**2025/0395**

**211A Spark Lane, Mapplewell, Barnsley**

**Single storey rear extension, creation of garage to right hand side of property, and associated alterations (amended plans)**

Front Elevation as Proposed

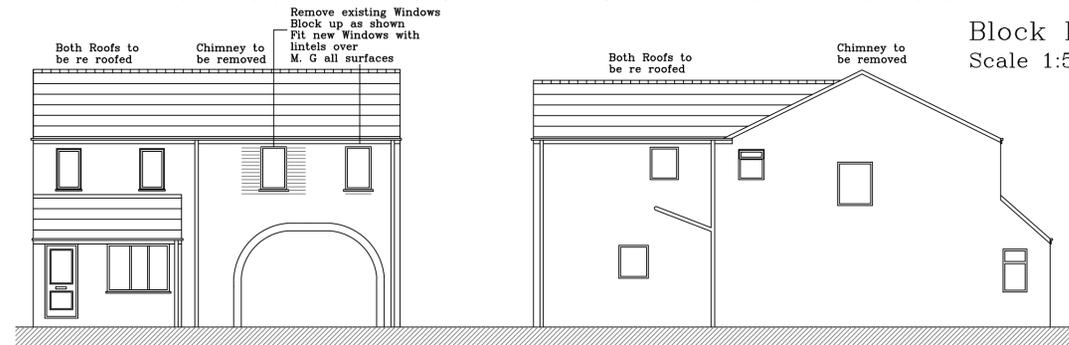
The alterations to the front elevation have been amended to create an enclosed garage as opposed to an open archway. The Local Planning Authority considered the archway to be out of character for the area and would have introduced an incongruous addition to the street scene. Following discussions with the Planning Agent the plans have been amended to incorporate a garage as an alternative. This is more sympathetic to the host dwelling and fits in with other properties in the street scene as there are a number of properties with integral garages along this stretch of Spark Lane.

Rear Elevation as Proposed

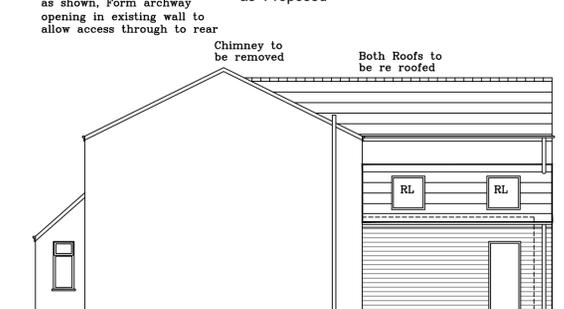
The proposed single storey extension does not raise any concerns, it is sympathetic, small scale and tucked between an existing extension and rear wall of the property therefore would have minimal visual impact. The extension will be brick built to match the host dwelling.

The single storey extension to the rear is an infill extension tucked into the corner between the rear wall of the dwelling and side of the existing two storey extension. It extends approximately 5.6m beyond the original rear wall of the dwelling and meets the rear wall of the existing extension. In terms of its width it is only 1.8m wide and does not extend as far as the side of the dwelling. As such is sufficiently distanced from the property boundary and windows and doors would not create a loss of privacy for neighbours. Furthermore, the positioning of the extension in the southern corner of the existing dwelling means very limited overshadowing would occur.
